Please ask for: Ms Iqraa Malik
Email: iqraa.malik@terraquest.co.uk
Telephone: 01212341390
Our Ref: BR/63/21/HH
Your Ref:
Date: 8th March 2021

Application for Planning Permission for Works or Extension to a Dwelling

Development: kitchen extension
Location: 2a Merchant Street Bognor Regis PO21 1QH

Proposed First Floor Plan

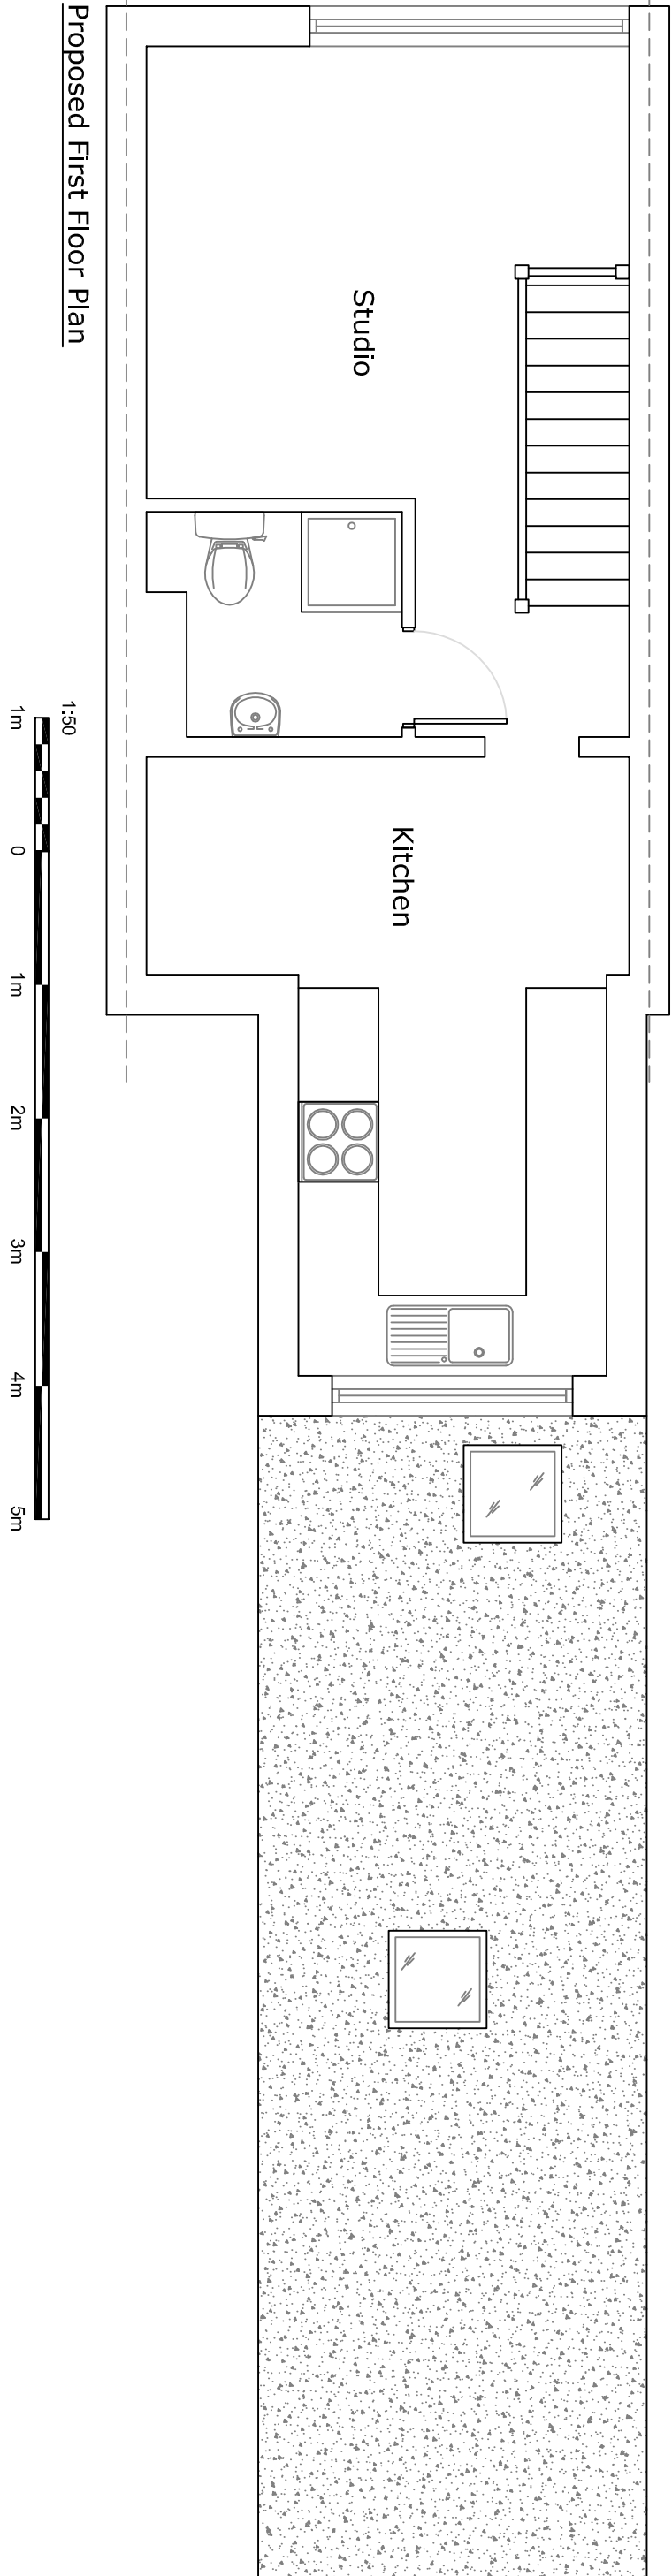
Please add room labels on the floor plans.

Please add a scale bar on all plans.
